DRB CASE ACTION LOG - BLUE SHEET

Project# 11010307 Application # 15DRB-70078

PROJECT NAME: Journal Center

DESCRIPTION OF REQUEST: Final Plat Approval for lot split of Tract 3A-1A-1A, Journal Center into two new tracts 3A-1A-1A-1 and 3A-1A-1A-2

**Proposed Tract 3A-1A-1A-1**  
 AREA=2.3799 Acres±  
 103,669 Sq. Feet±

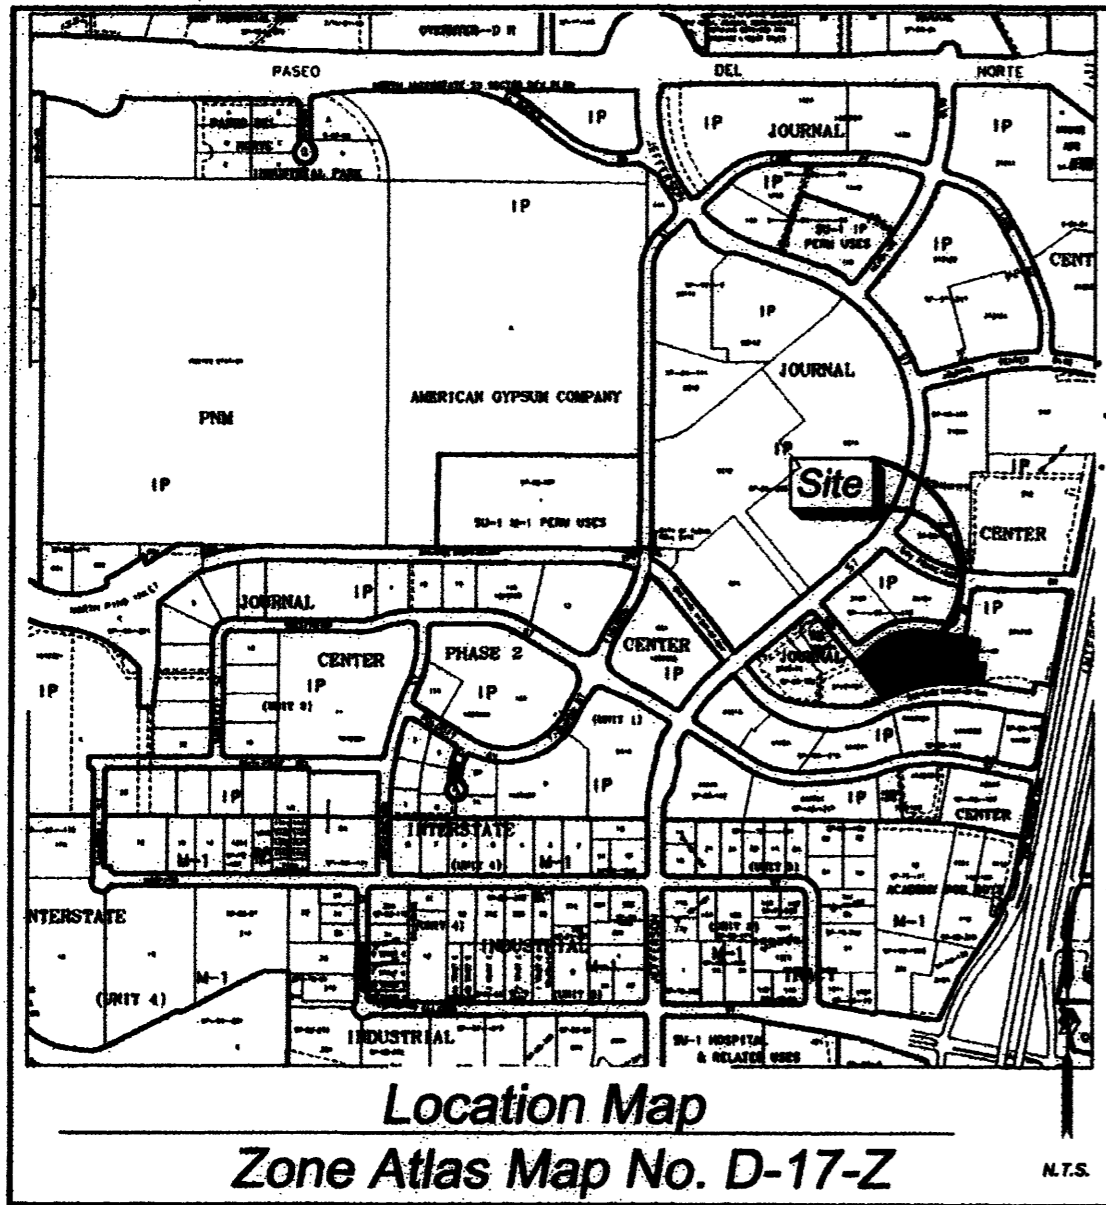
Conformance with Planning and Zoning is required in Section 14-14-2-2 of the Subdivision Regulations, which means an approved site plan is needed with the lot line shown. Applicant needs to show how parking calculations were determined for both site plan and plat. Reciprocal easements are needed with platting (access, drainage, etc.).

Plat of  
**Tracts 3A-1A-1A-1 and 3A-1A-1A-2**  
**Journal Center**  
 Albuquerque, Bernalillo County, New Mexico  
 February 2015

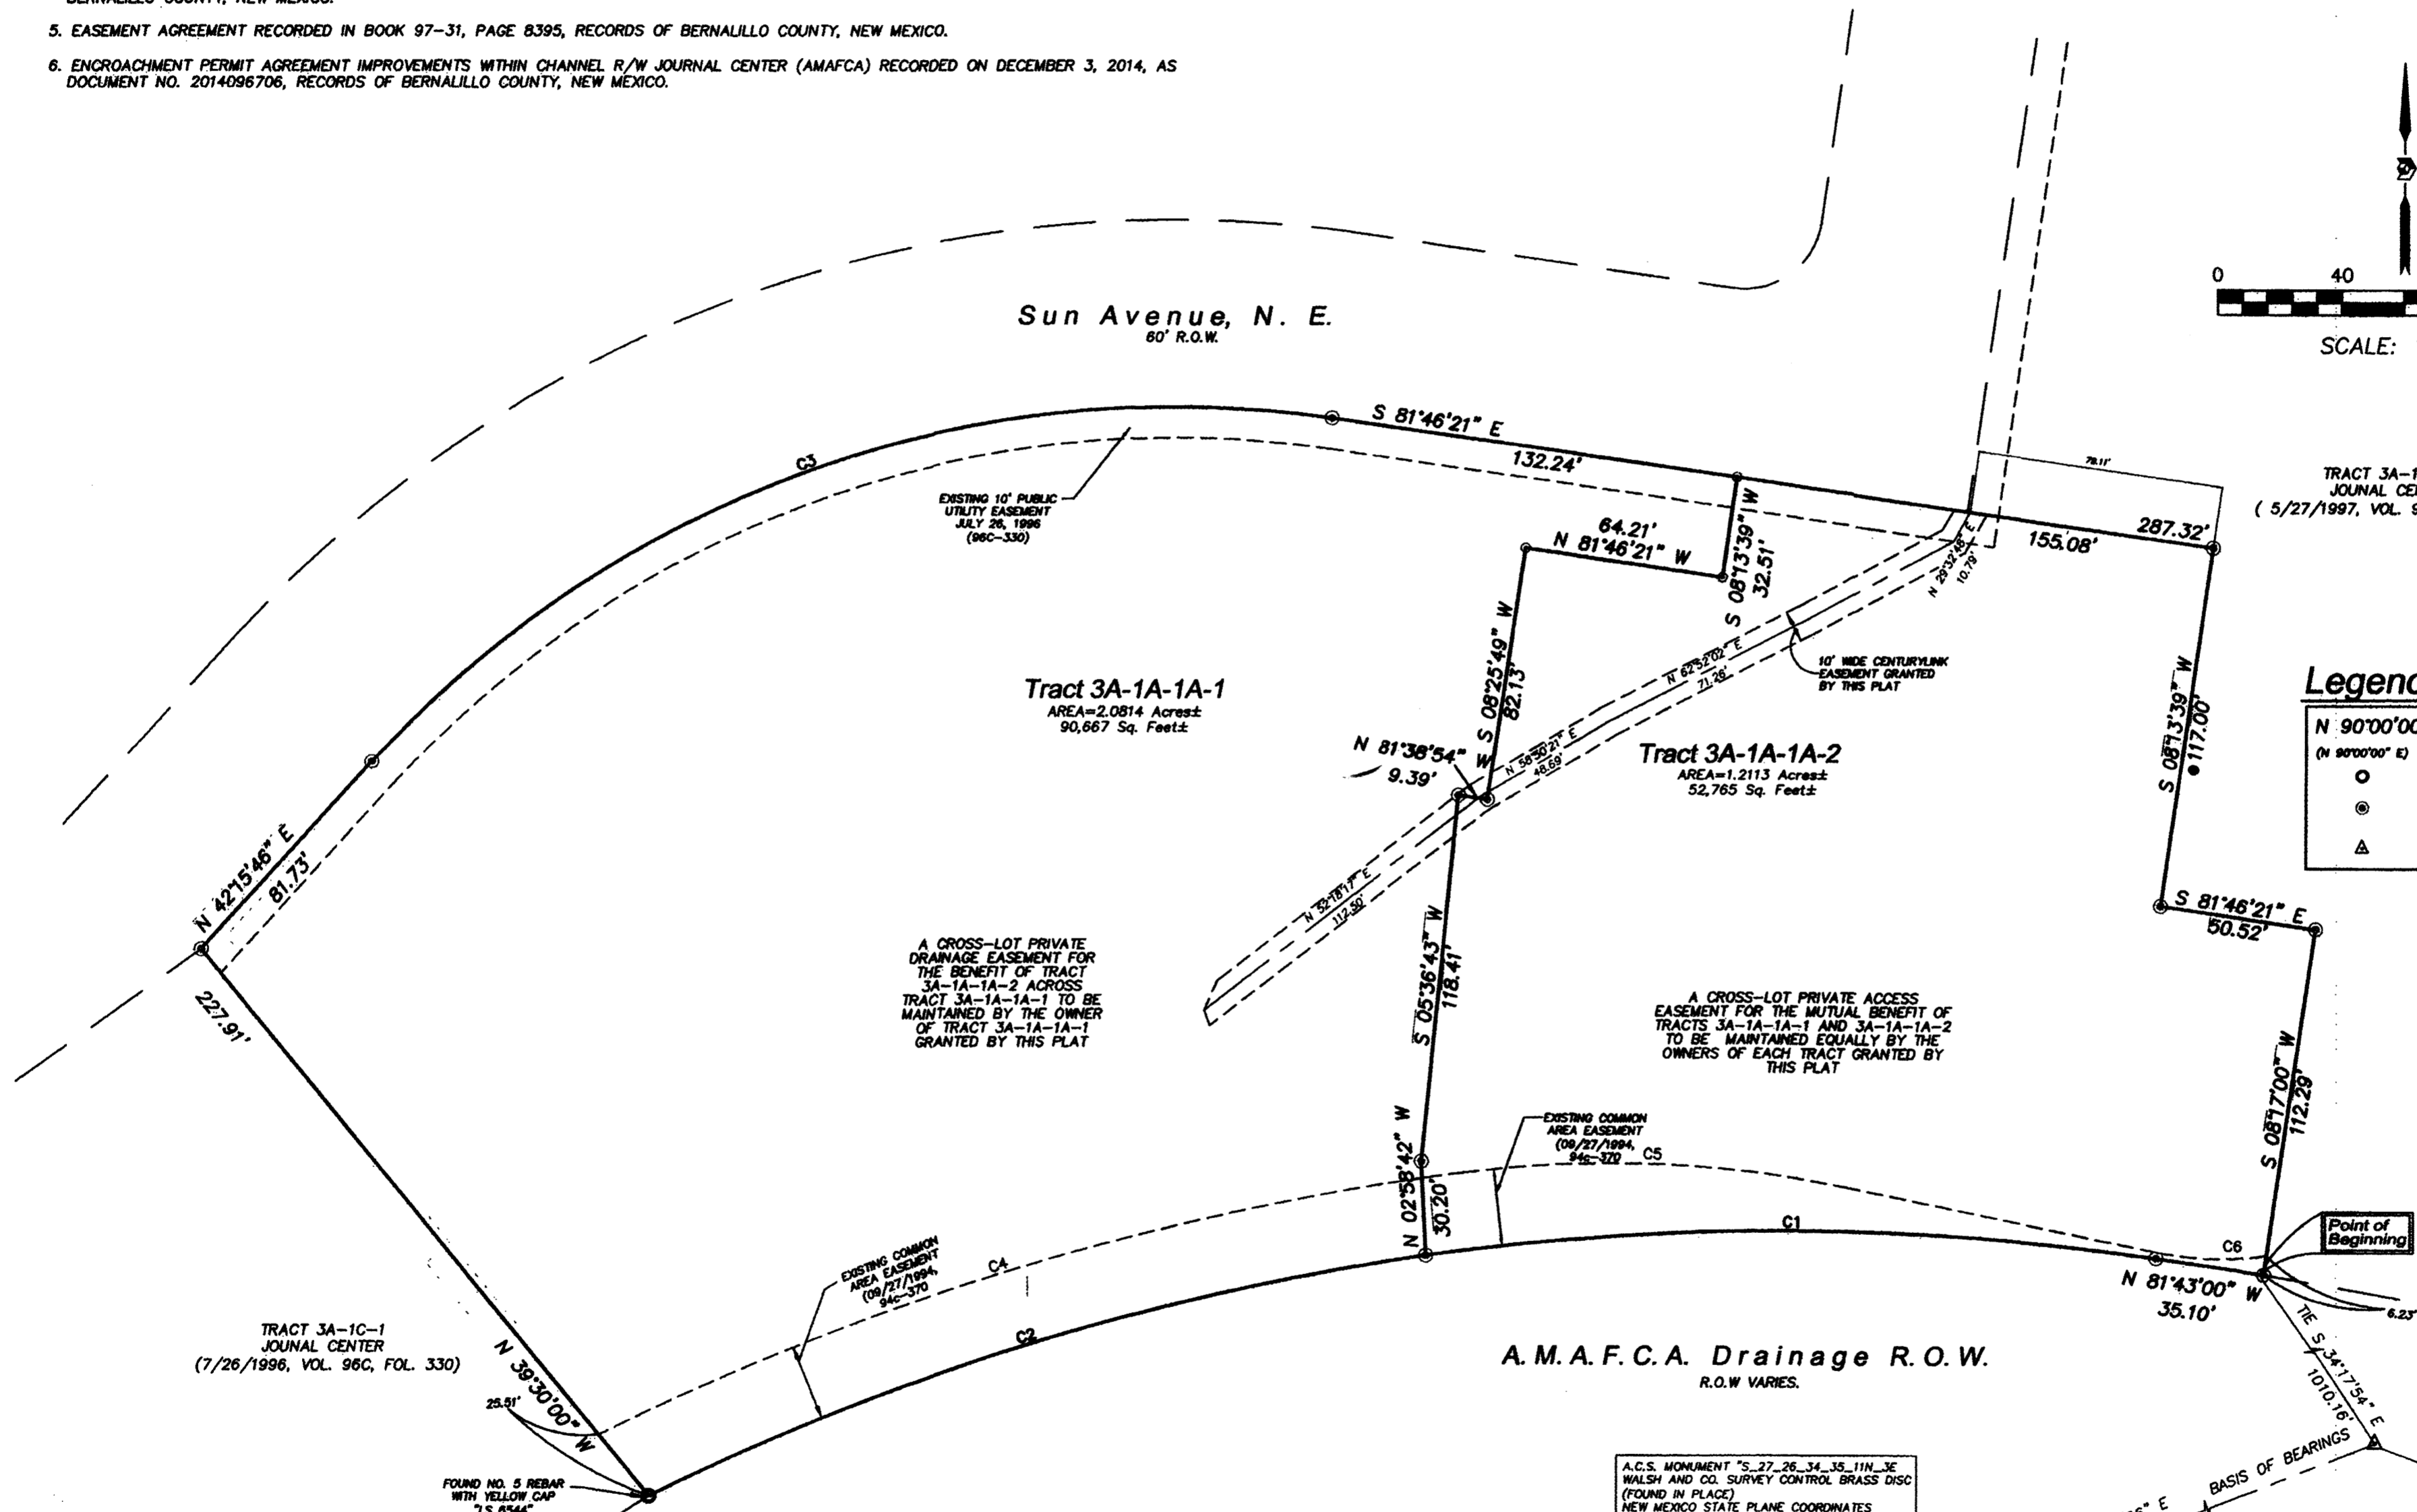
Transportation: Exhibit w/ dimensions

Planning: utility signature, idyl, approval site plan
